MEMORANDUM

TO: Molly Casto
FROM: Dan Goyette, PE, and Lauren Swett, EIT
DATE: August 13, 2007
RE: Estates of Longfellow Inn

Woodard & Curran has reviewed the site plan application for the Estates of Longfellow Inn, located at 130 Eastern Promenade. The project proposes to renovate an existing 11-unit apartment building, including the demolition of one section of the building and the construction of a new addition, resulting in a 9-unit apartment building.

PROPOSED CONDITIONS DRAINAGE MAP
THE ESTATES OF LONGFELLOW INN
 130 EASTERN PROMENADE
 PORTLAND
 MAINE

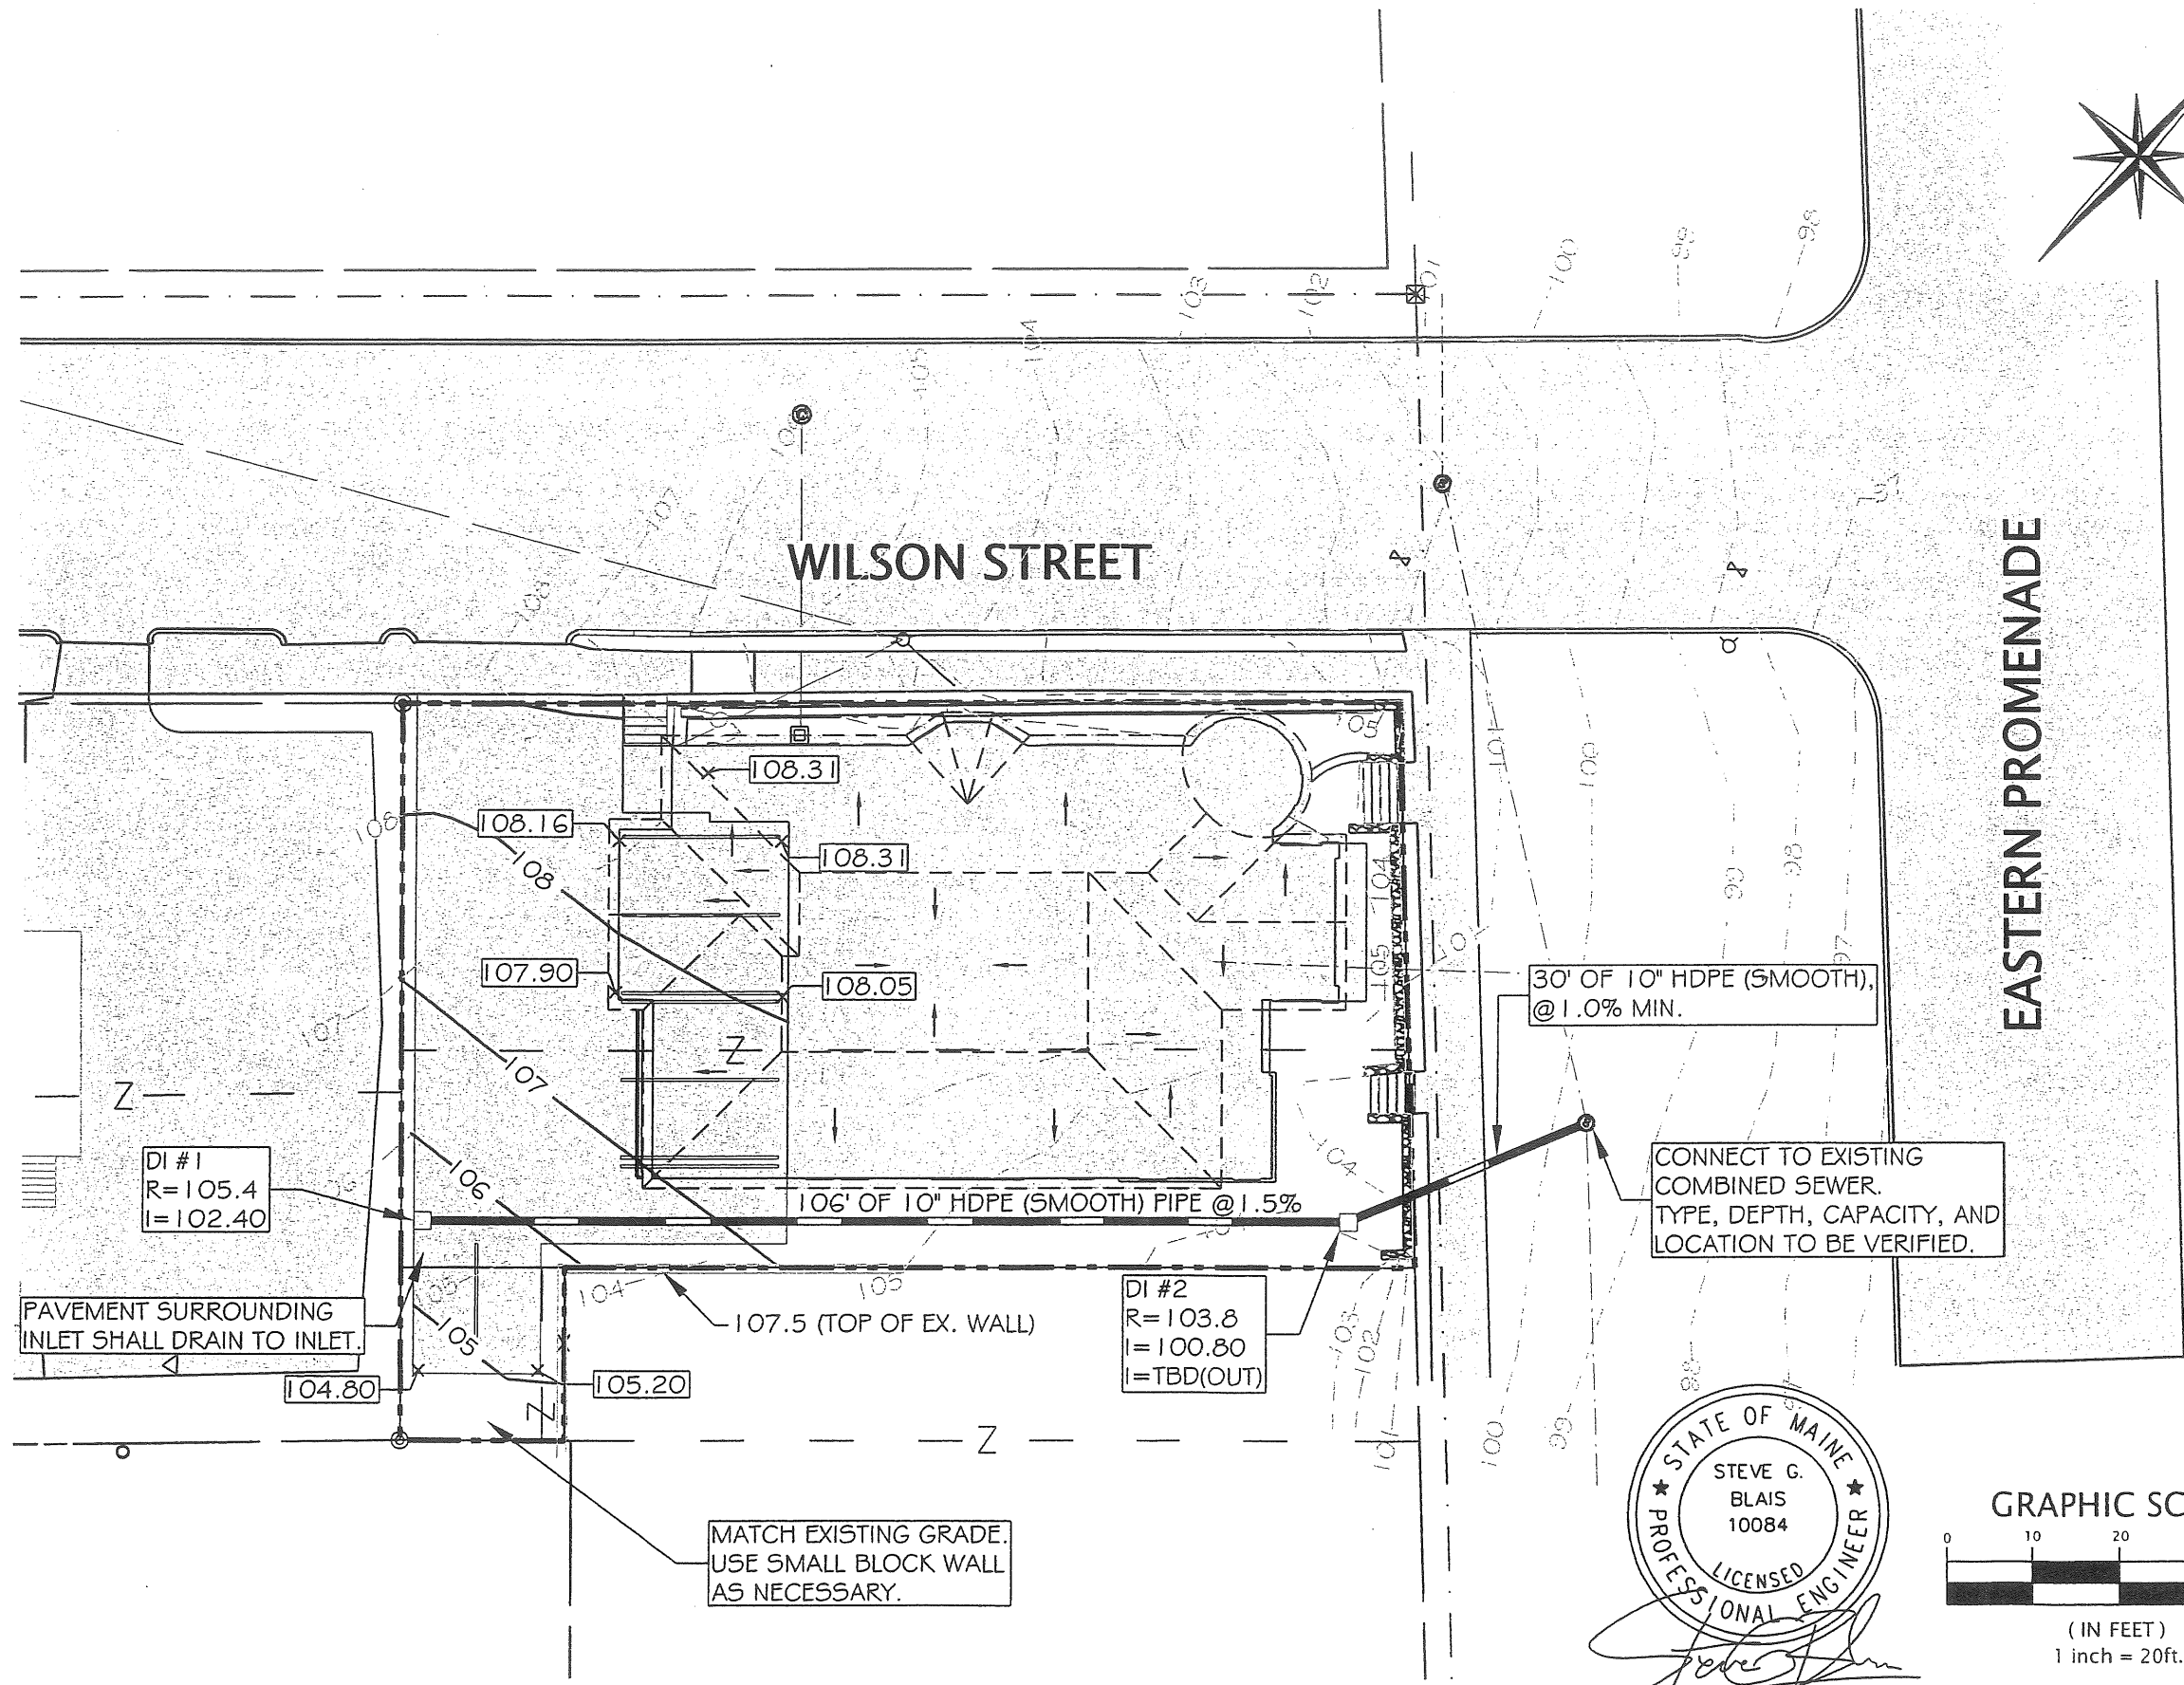
- No stormwater calculations have been provided. The applicant states that the total impervious surface will increase, but there will be a net decrease in total runoff. This should be quantified using Hydrocad or another calculation method.
- A drainage swale has been called out on the site plans to be located at the northwestern corner of the building, near the section of pavers. No grading or details have been provided for this swale. The swale may need to be taken into consideration in the stormwater calculations.
- An erosion control plan, providing details including timing for the installation and removal of erosion control measures should be included.
